RE: Graybill Short Plat (SP-09-00006)

The Kittitas County Community Development Services Department has determined that the Graybill Short Plat (SP-09-00006) is a complete application and hereby grants *conditional preliminary approval* subject to the following conditions:

GRAYBILL SHORT PLAT
PART OF SECTION 34, T. 17 N., R. 19 E., W.M.
KITTITAS COUNTY, WASHINGTON

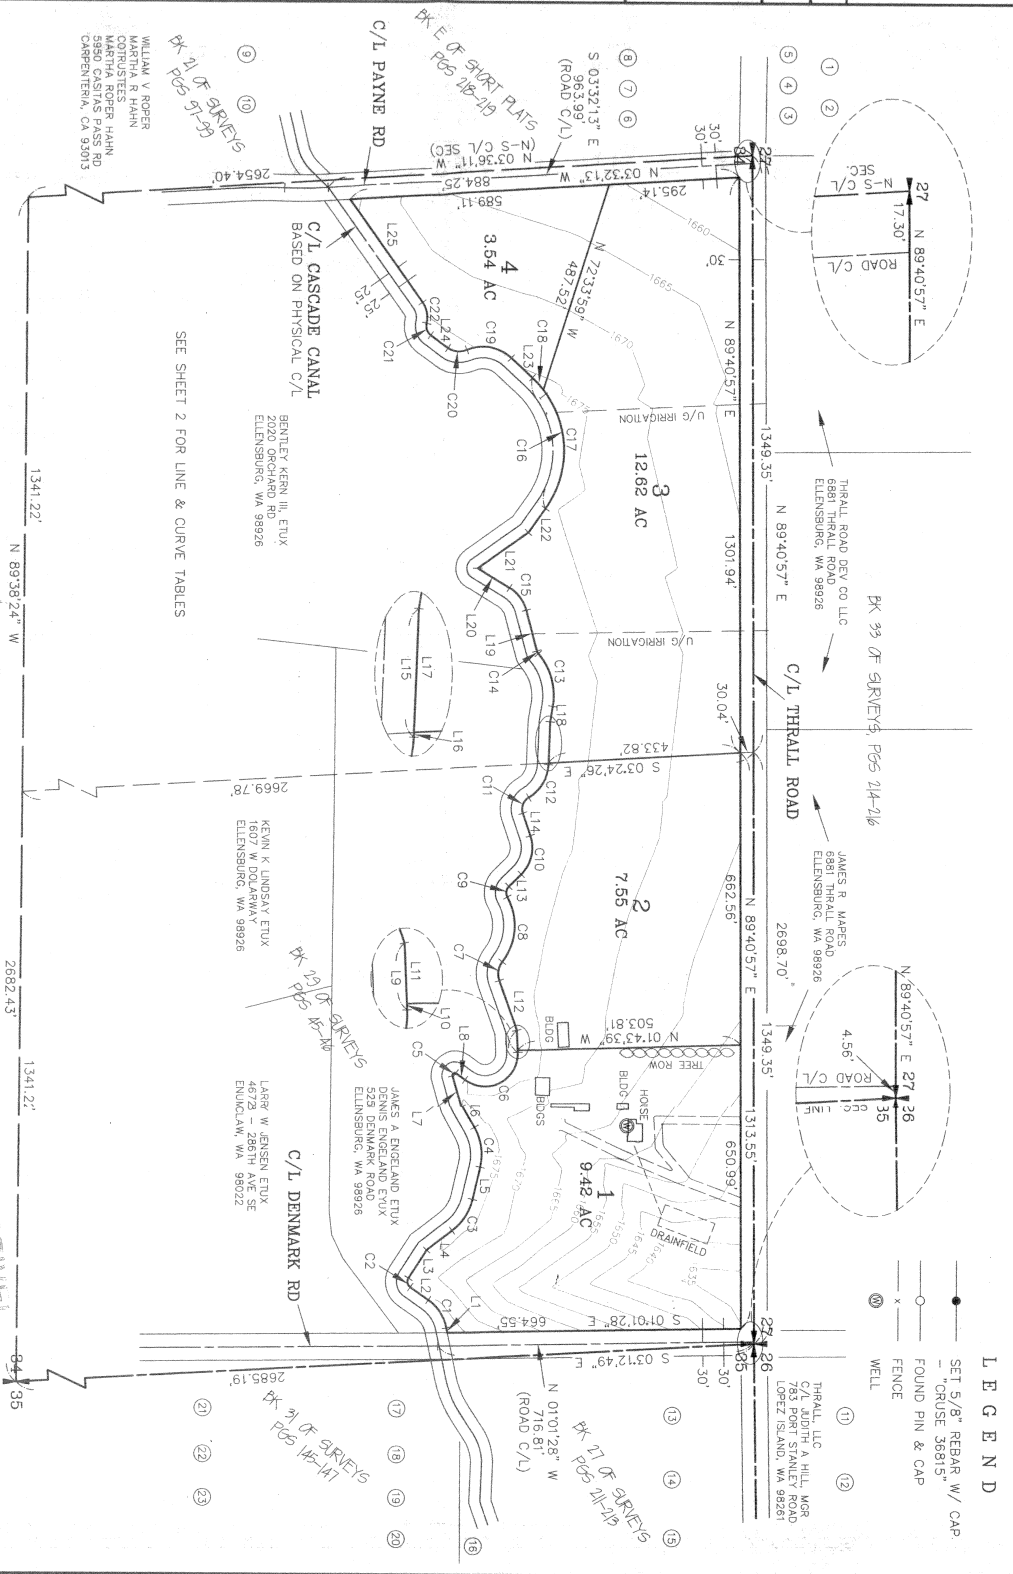
1. Both sheets of the final mylars shall reflect short plat number SP-09-00006 and an accurate legal description shall be shown on the face of the final plat.

2. Full year's taxes must be paid on all tax parcel numbers per requirement of the Kittitas County Treasurer's Office.
3. The following plat notes shall be recorded on the final mylar drawings:

4. If distribution of the available water between parcels is different than listed above, specify the quantity of water in gallons per day by parcel on the final mylar.

10. Per Kittitas County Environmental Health, soil logs need to be performed and proof of water availability is needed. Evidence of both shall be provided to Community Development Services prior to final approval.

11. The addresses shall be clearly visible from both directions at the County Road for all properties.
12. The Fire Department access road shall be capable of supporting 75,000 lbs in all weather, be 20' wide, provide 13'6" vertical clearance and provide for adequate turn-around for fire department apparatus.
